Our ref: 7033/2.7/SL

25th June 2020

Angels Nursery, Yapton

In response to your e-mail dated 16th June, please see below our responses in Green and our drawings and calculations enclosed for your approval.

DRAWING No. 19812-GS-Z1-XX-DR-C-5102

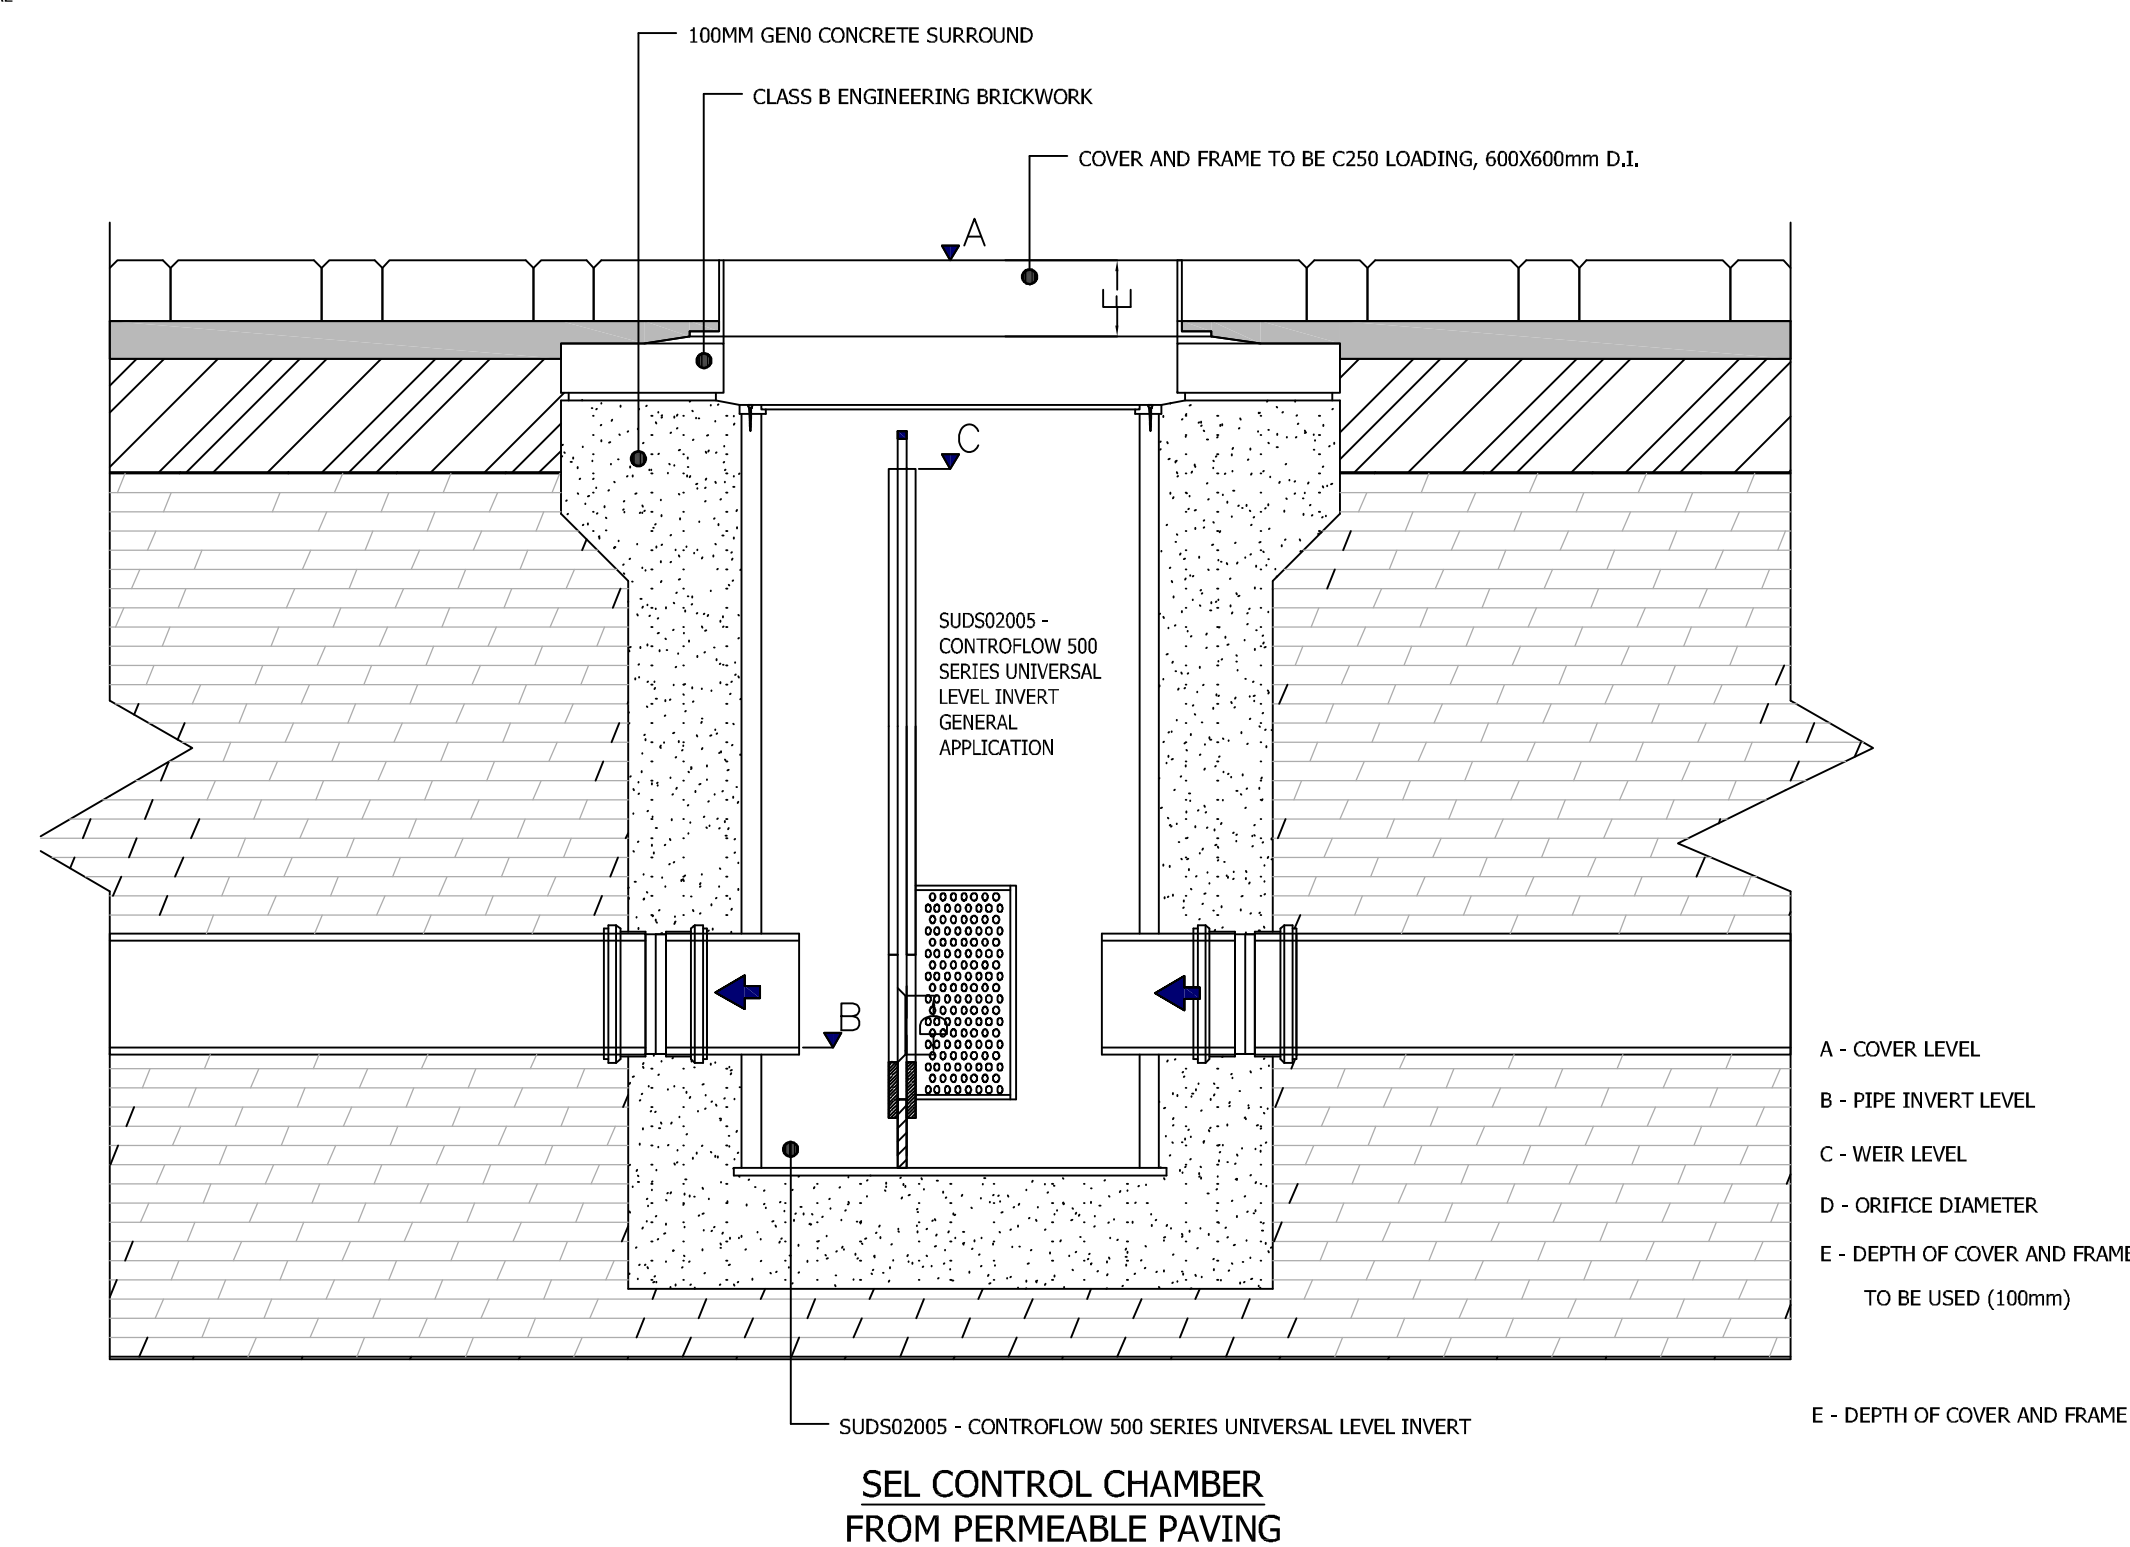
54. SMH control manhole on pond outlet – overflow pipe shown on plan? *Overflow not shown on detail. Please provide site specific detail. Revised on drawing 5102.*

64. Hydrobrake chamber detail – rings to be surrounded in 150mm thick concrete and to be extended down to the bottom of its base. All to be ST4 concrete. Add benching construction notes and include hydro international details referred to. *Note is not clear that surround extends to bottom of base, benching note missing, hydro international details not included.* See revised detail on drawing 5102.

DISTRIBUTION/COLLECTOR TANK DETAIL WITHIN TANKED PERMEABLE PAVING (MARKED DT ON LAYOUT)

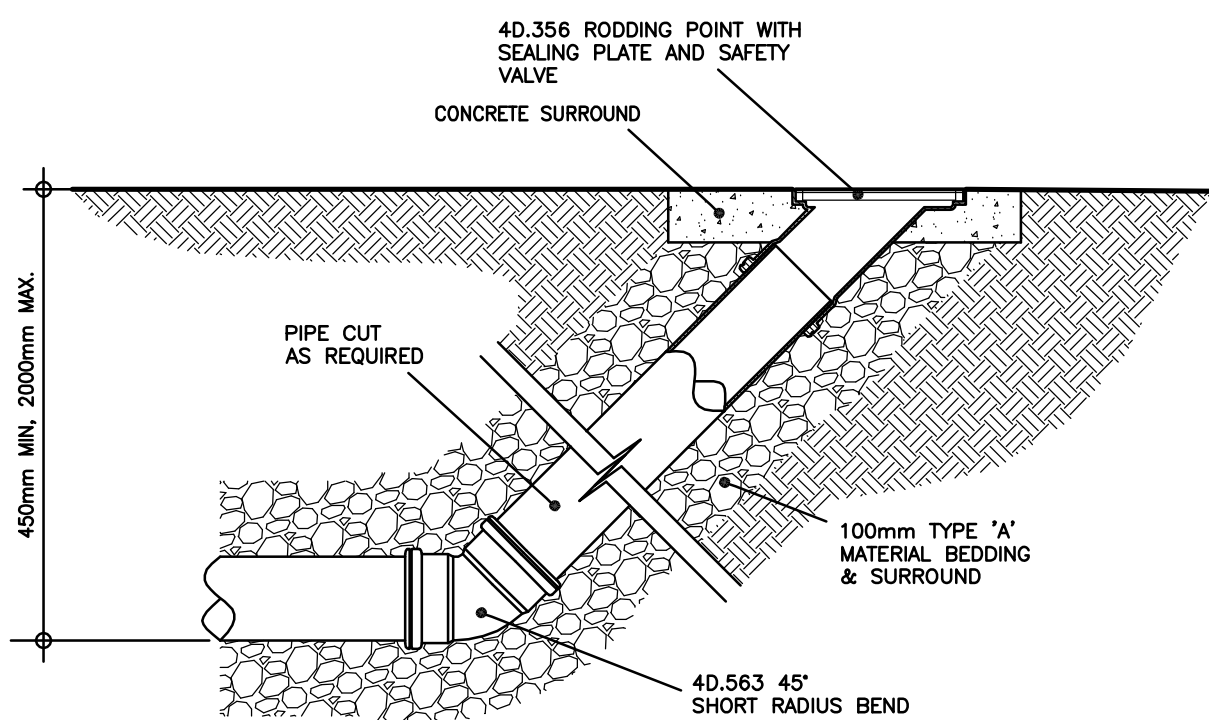
73. Provide construction detail distribution tanks on permeable paving outlets. *Please make it clear that invert level of outlet tanks is at formation level.* Note added to DT detail on drg 5101.
